CITY OF MERCER ISLAND

Pre-Application Meeting (PRE23-022)

Site Location:	4153 Boulevard PL	Parcel Number	362350-0456
Lot Size:	15,000 sq ft	Zoning:	R-15 (Single Family)
Brief Project Description:	Interior remodel/alteration with minor structural work. Replace exterior roof, siding, windows, and doors. Repave driveway. Reinforce driveway retaining wall and install new walking path paving.	Documents Provided:	<ul style="list-style-type: none">• Project narrative.• Pre-application meeting form.• List of questions.• Site plans.
Applicant Information:			
Name:		Email:	Phone:
Owner: Russell Vandebelt & Linda Vandebelt. Contact: Jim Tung (Tyler Engle Architects)		jim@tylerengle.com	(206) 621-7241
Second Pre-application Meeting Required:	Not Applicable

COMPLIANCE CALCULATION FOR MICC 19.01.050(D)(1)(b)(i)

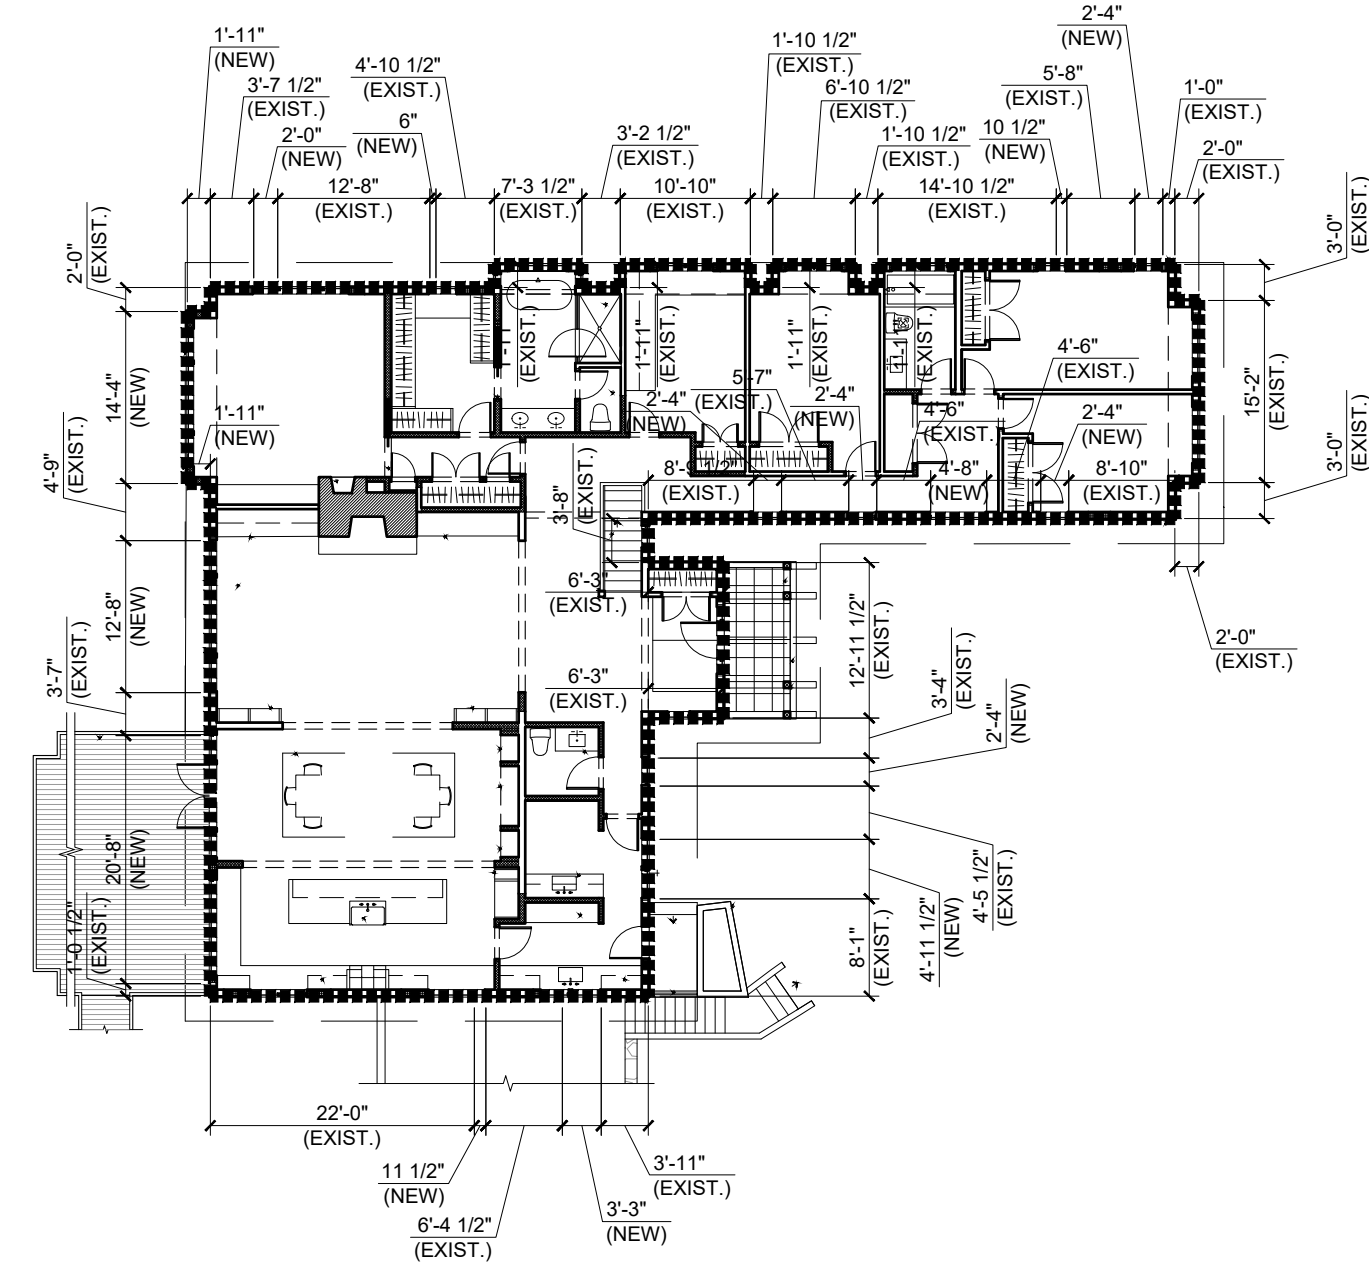
1. The current house was built in 1952 and the yard orientation has since changed. The nonconforming north setback in grandfathered. The applicant would like to add a bay window at the upper level of the west side of the house that is within the non-conforming setback. The bay window would not extend out past the existing eave of approximately 28" in depth, therefore not increasing the nonconformity. We need to know if this is permissible.

It will need to be shown that the bay window will not extend past the current eave and not increase the current nonconformity. Calculations will also be needed to show less than 40% of the exterior walls are being structurally altered.

Staff Response: Per MICC 19.01.050(D)(1)(b): "A legally nonconforming detached single-family dwelling may be intentionally altered or enlarged without losing its legal nonconforming status as long as no more than 40 percent of the length of the dwelling's existing exterior walls, excluding attached accessory buildings, is structurally altered."

1 EAST ELEVATION AT EXIST RETAINING WALL

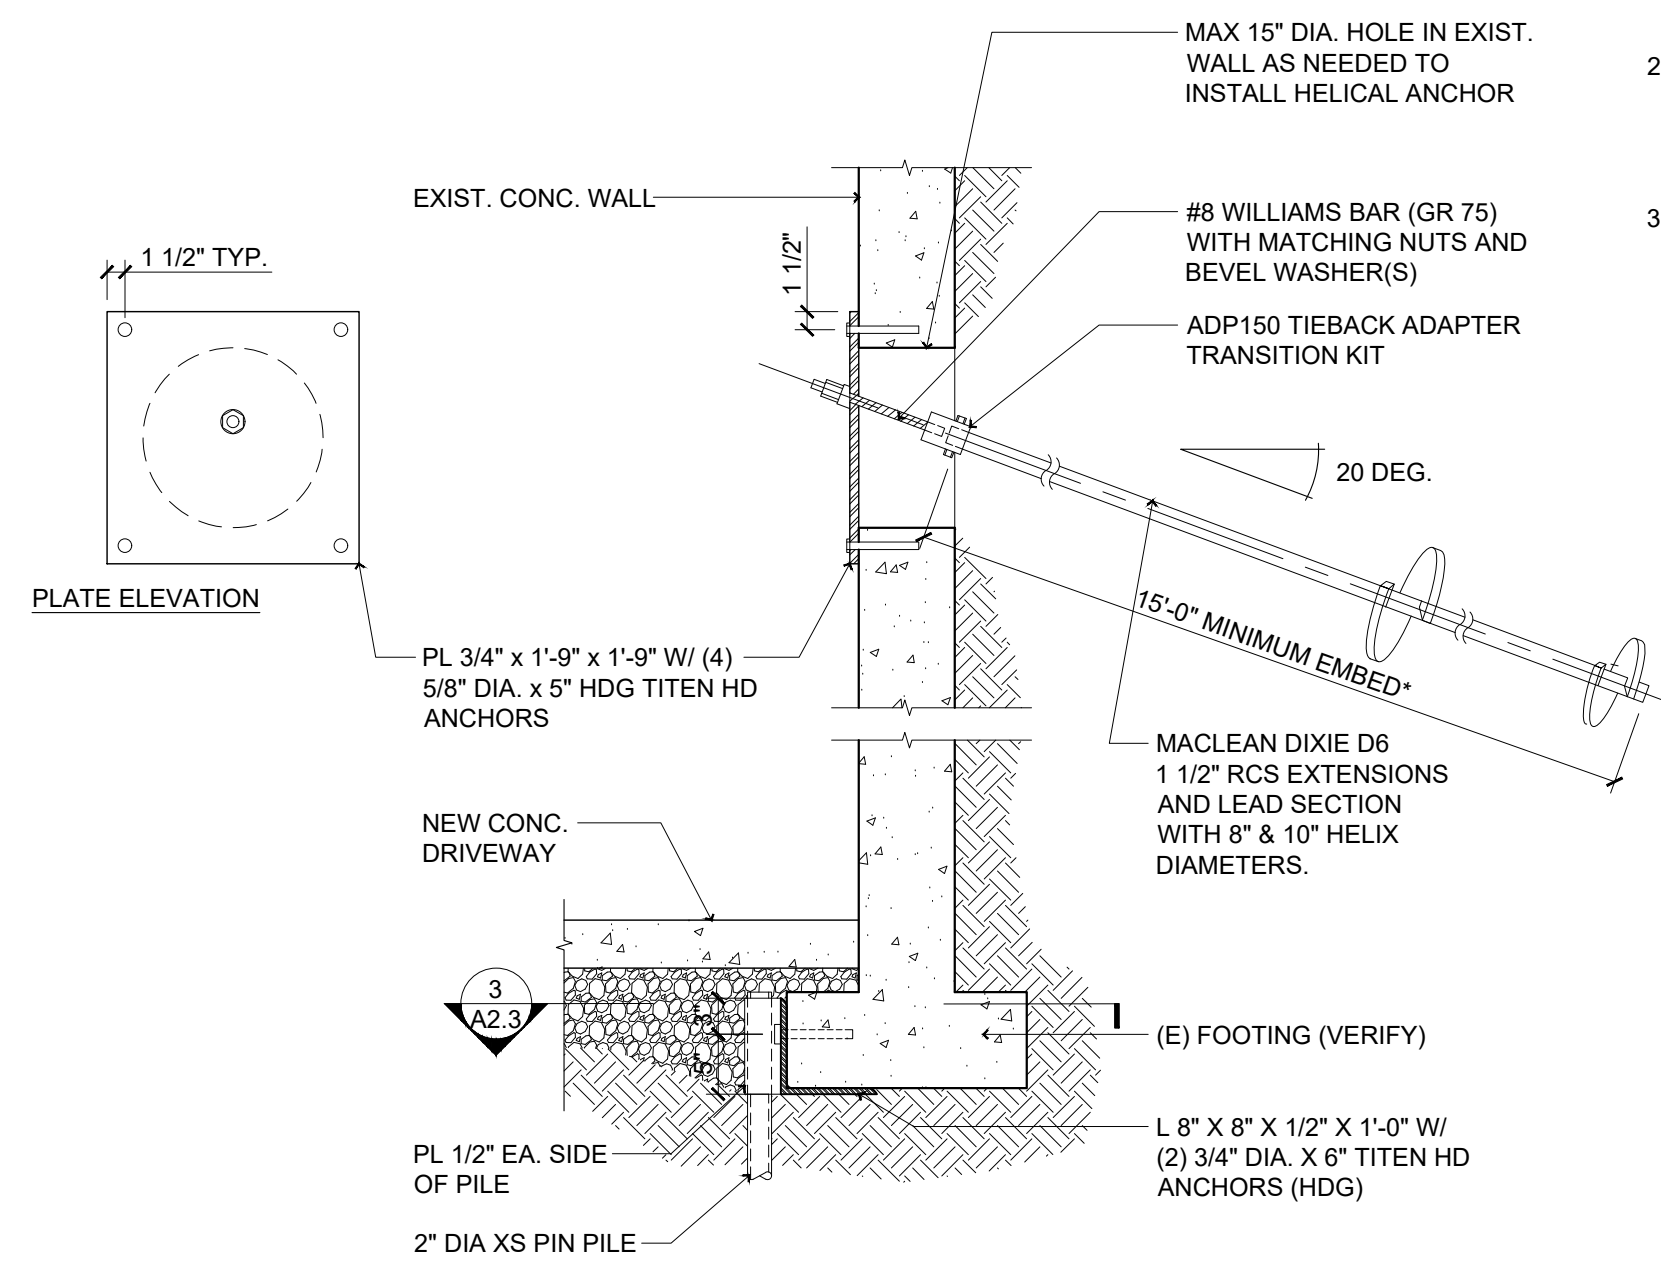
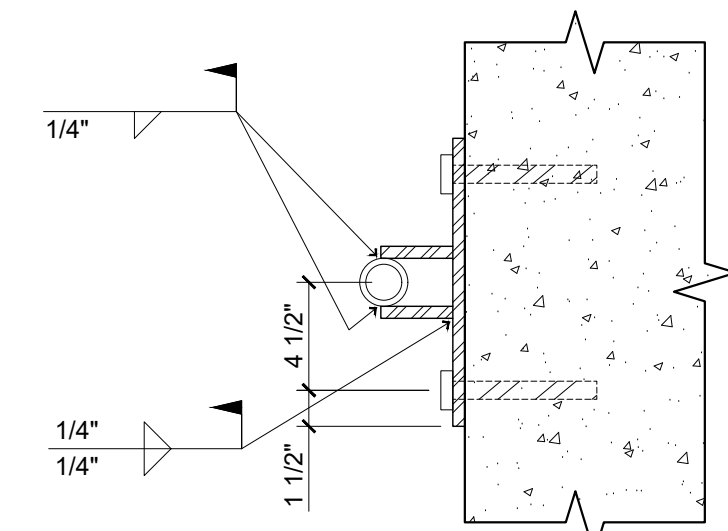
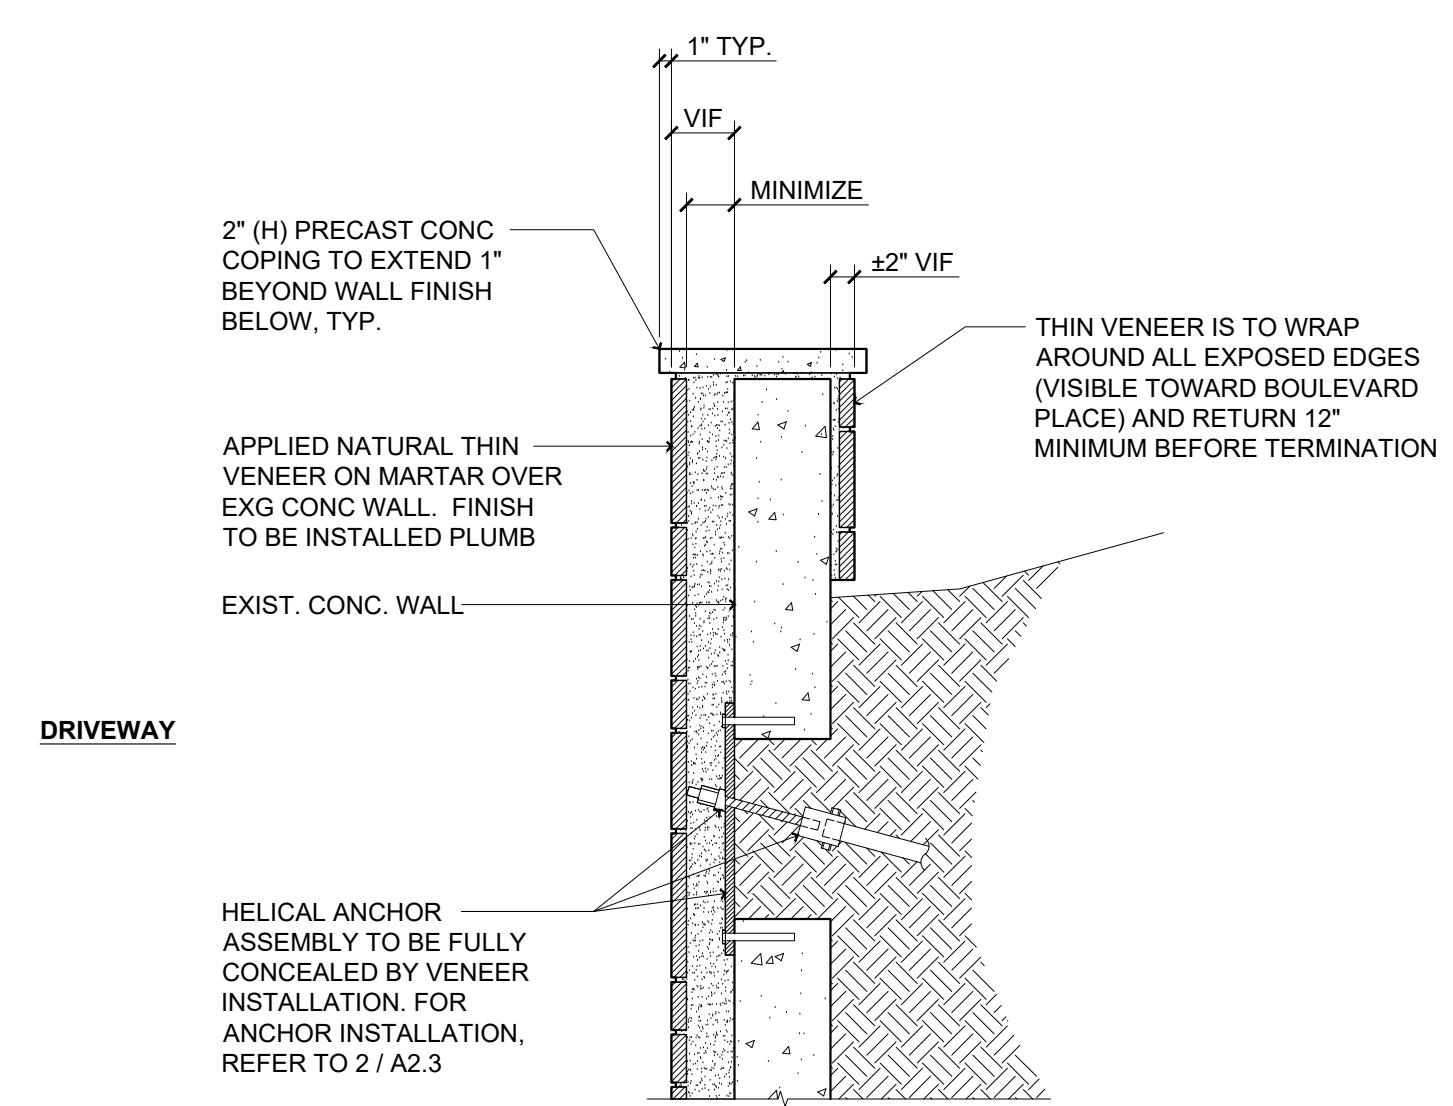
1. Please refer to MICC 19.10 for our tree code.
2. 30% of trees with a diameter of 10 inches or greater is required; additionally, development must be designed to minimize tree removal. All exceptional trees need to be protected. If more than 500 square feet of new impervious surface or gross floor area.
3. Replacement is required for any trees that are removed, according to the replacement ratios in MICC 19.10.070.
4. Confirm the dead maple has been removed. Or contact public works to have the dead maple on the right of way removed customerservice@mercerisland.gov.
5. Please describe the retaining wall repair work near the city Douglas fir. Further excavation could damage or destabilize the tree.
